Application Number: 2022/23743/HH

Proposal: Demolition of conservatory. Two storey side extension and single storey rear extension.

Site Address: 10 Clayton Hall Road, Cross Hills, Keighley, BD20 7TB,

Proposed Site Plan + Sunlight track.

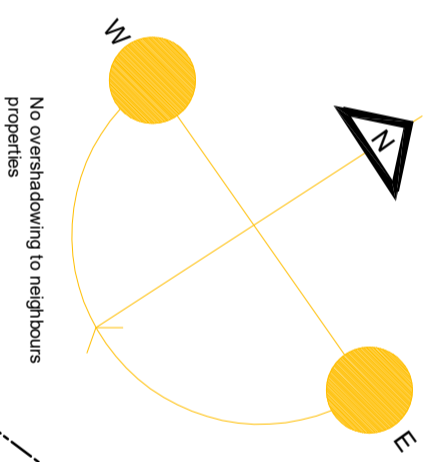
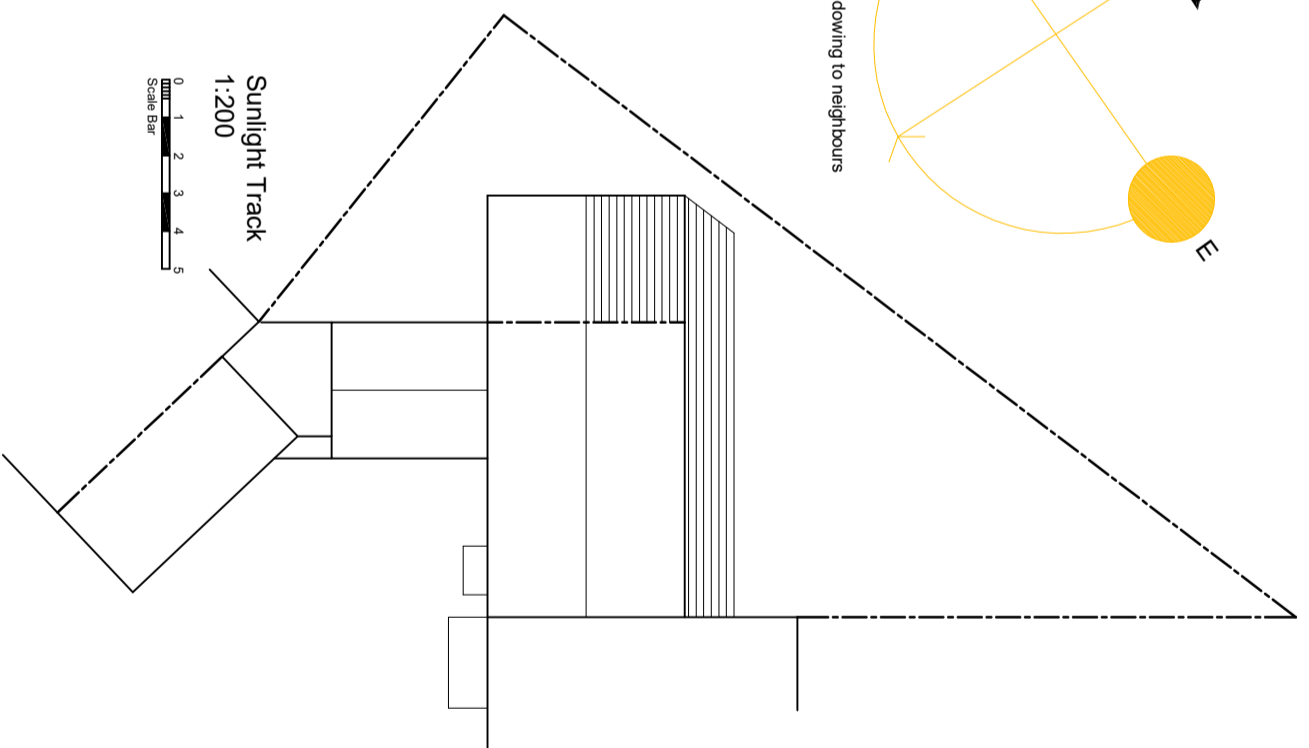
- 9.6 The single storey extension would be located facing into the applicants' private garden space and would only be visible from first floor windows of the property at 3 Clayton Fold located immediately to the north of the application site. Due to the orientation of the neighbouring property the proposed extension would not result in any loss of privacy or create any overshadowing or overbearing impact. On this basis, the single-storey extension is considered to be acceptable in terms of amenity and to be consistent with the requirements of both the NPPF and relevant Local Plan policies.

- 9.7 The proposed two-storey extension would be located close to the property boundary shared with 3 Clayton Fold but would not incorporate windows at first floor level to either the north-east or north-west facing elevations. A first-floor window is proposed to the southern elevation of the two-story extension which would face towards the neighbouring property at 12 Clayton Hall Road and allow oblique views across the neighbouring garden and towards the rearward facing windows of that property. However, there are existing windows at first floor level on the existing host property and it is considered the additional overlooking would not be sufficient to warrant refusal of planning permission. With regards to the visual impact and potential

overshadowing that might arise from the proposed two-storey extension it is considered that the proposals would not impact upon amenity to an extent that would be unacceptable.
